Planning Application Ref: P/63/20/T

Location: 18 Boleyn Drive, Pagham, PO21 3LG

Description of works: Reduce height to approx. 8m and crown thin by 20% 2No. Lombardy poplar trees

PLAN TO SHOW POSITION OF
2 LOMBARDY POPLAR TREES IN
REAR OF GARDEN OF
18 BOLEYN DRIVE,
PAGHAM, WEST SUSSEX

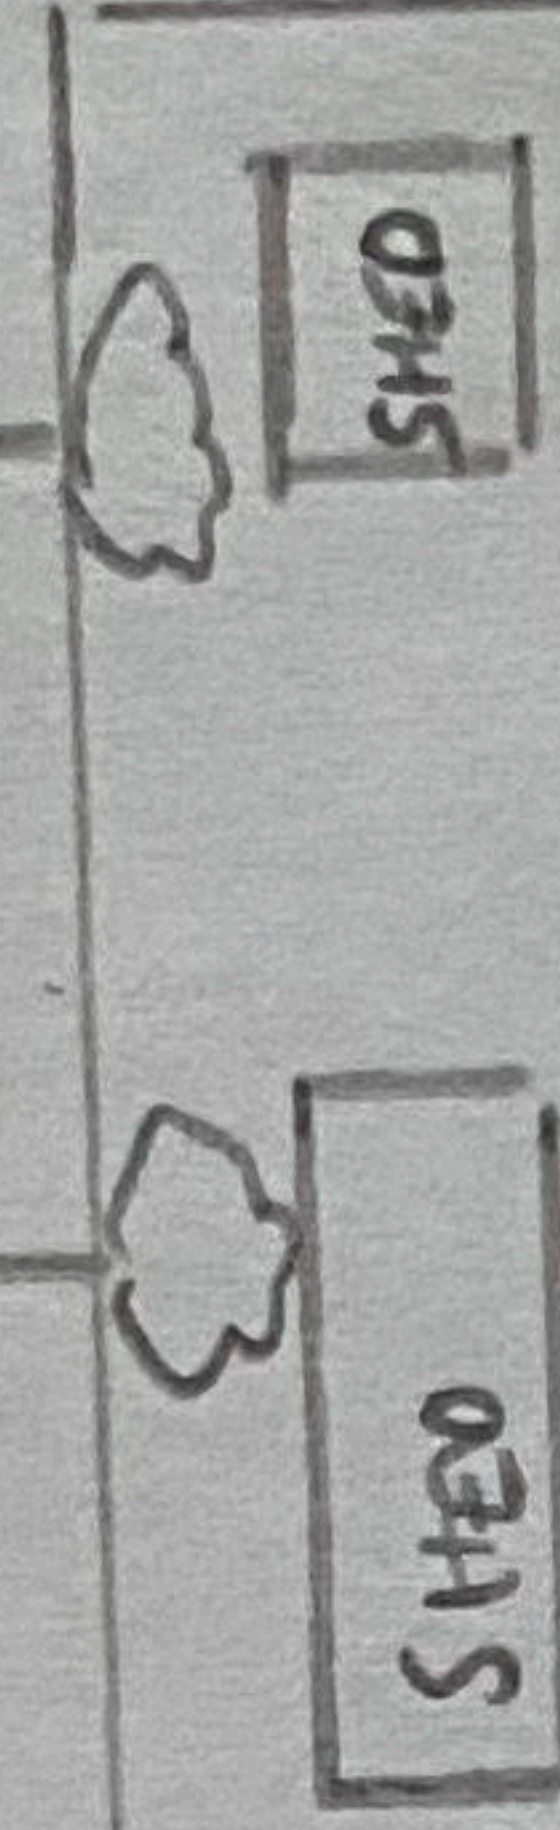
2x Lombardy poplar / *Populus nigra Italica* Height: 10-15m Radial spread: 0-5m Age class: Early mature

- Outwardly and from a distance both trees appear to be in a fine physiological state. They have previously been the subject of reduction pruning on a number of occasions, last undertaken c.2017.
- Further reduction pruning will be necessary throughout the remaining lifespan of these trees, to achieve a reasonable degree of structural integrity appropriate for their location. They grow at the rear of the property and can be seen from neighbouring dwellings but are visible only in small part from publicly accessible land.
- The crown thinning element appears unnecessary and unlikely to provide more than a short-term effect, although tolerable if executed correctly.

- The proposal to reduce its overall height and spread with a view to restricting its growth is justified and consistent with previous works approved by the Local Planning Authority.
- While a temporary loss of aesthetic value is inevitable, satisfactory canopy renewal and recovery should occur if the work is undertaken to a high standard and at an appropriate time of year.

- I recommend **CONSENT** for this application, subject to the following condition:

- Part a) Where whole branches are to be removed and final cuts made close to the trunk or branch union they are to be made as shown in Figure 2 of BS3998:2010
- Part b) Where branches are to be shortened back the final cuts are to be made at the correct angle shown in BS3998:2010 and adjacent to a live bud or lateral.
- Part c) The removal of crown material which has developed since the last operation must be done sympathetically and with respect to established 'knuckles' so as not to extend beyond the point of origin.

- The long-term vitality of these trees is best respected when significant pruning work such as proposed, is undertaken during the mid-winter (late-December to early-February) period. The work should only be undertaken during this period.
